Ref: 20C-11-0070-GCO-268448-0

RE: Acoustic Comments – Response to Atkins Acoustics letter (43.6673.L2:GA/DT/2013)

Following our meeting of 24th April at Botany Bay Council and discussions regarding Atkins Acoustics comments on the acoustic report, we hereby provide our response to the points raised in the meeting.

Existing Saturday midday
peak hour traffic flows

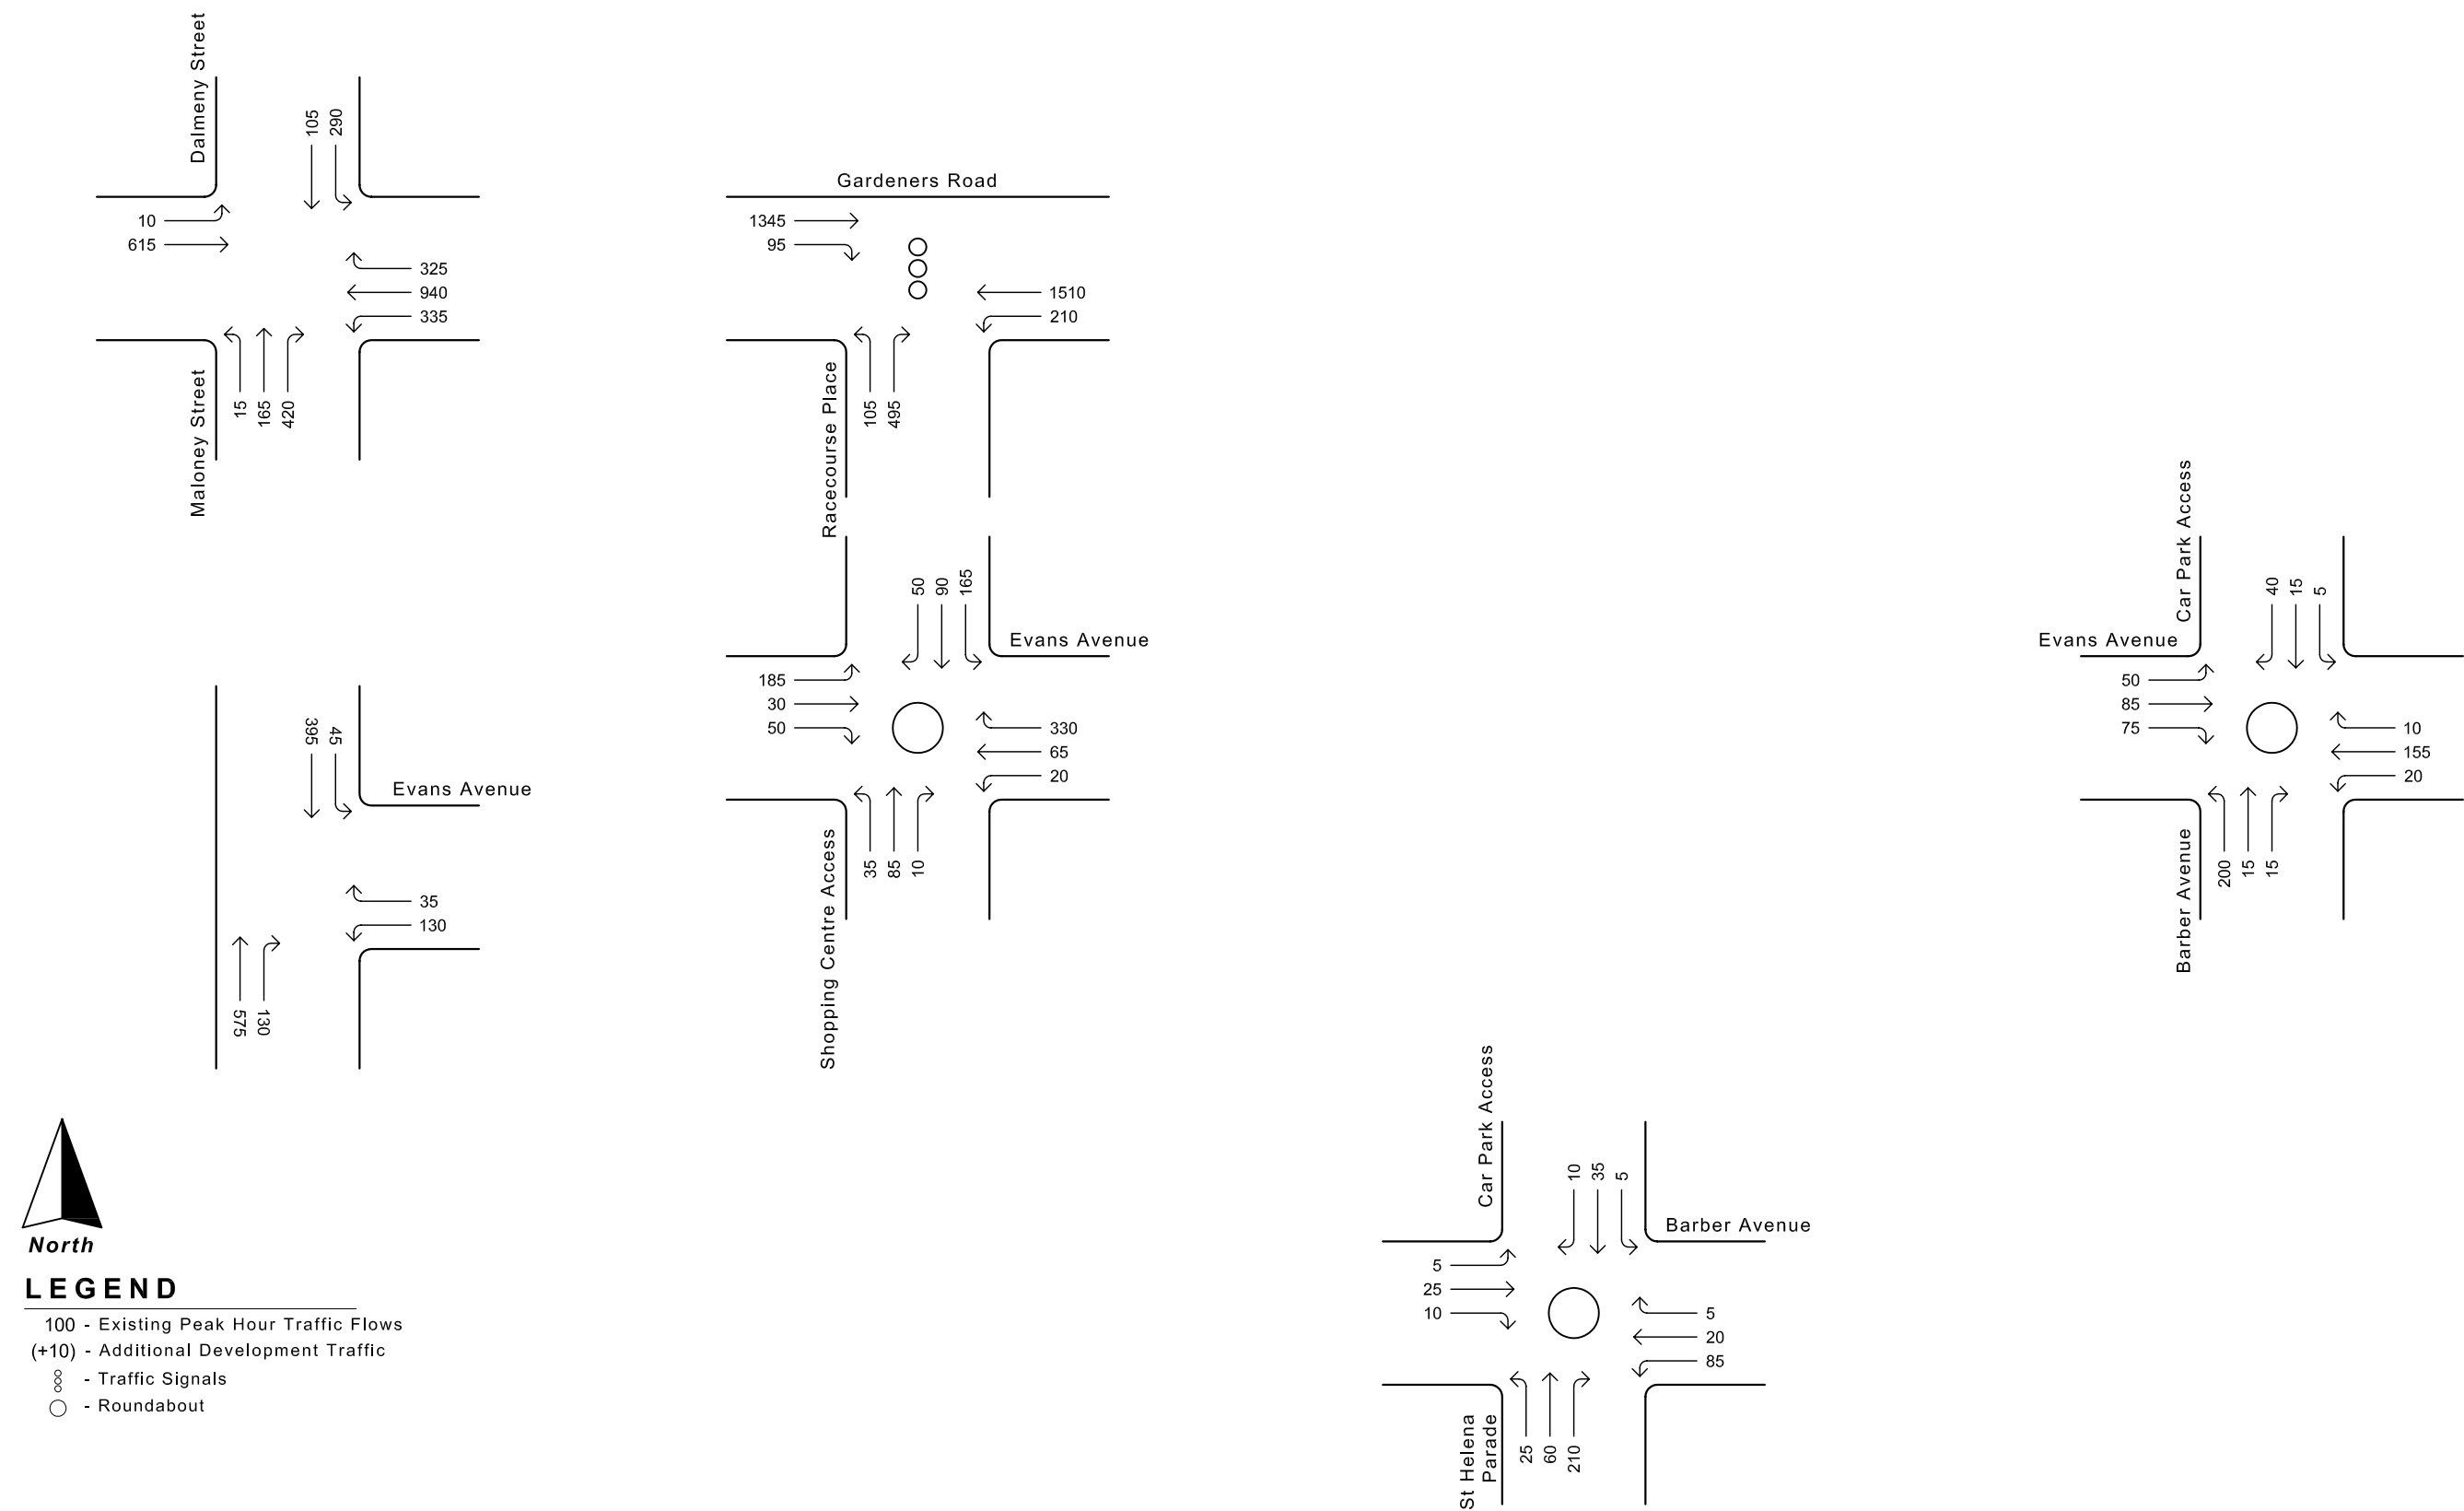
The noise level measurements presented in the acoustic report indicate that the existing noise levels exceed those levels recommended by the RNP. The traffic volumes presented in VIPAC Table 19 were obtained from CBHK traffic report dated April 2012 (Table 3.2), which was the only report available to us at that time.

The vehicle volumes are given for the three periods, Thursday morning, Thursday afternoon and Saturday midday (Tables 2.1 and 3.2 of the traffic report).

Generated traffic noise impacts based on the new traffic report dated July 2012 are calculated and presented below. The figures for existing traffic are for the residential and retail (including service) vehicles. The figures for the generated traffic are for residential and retail (excluding service) vehicles. The service vehicle volumes were added to the figures to calculate the cumulative noise impact.

Service vehicles primarily access the centre from Gardeners Road, via Racecourse Place. Large service vehicles access the centre from Maloney Street, via Evans and Barber Avenue. The following Table 2 and Table 3 present a summary for total generated traffic volumes and the cumulative noise impact from the generated traffic.
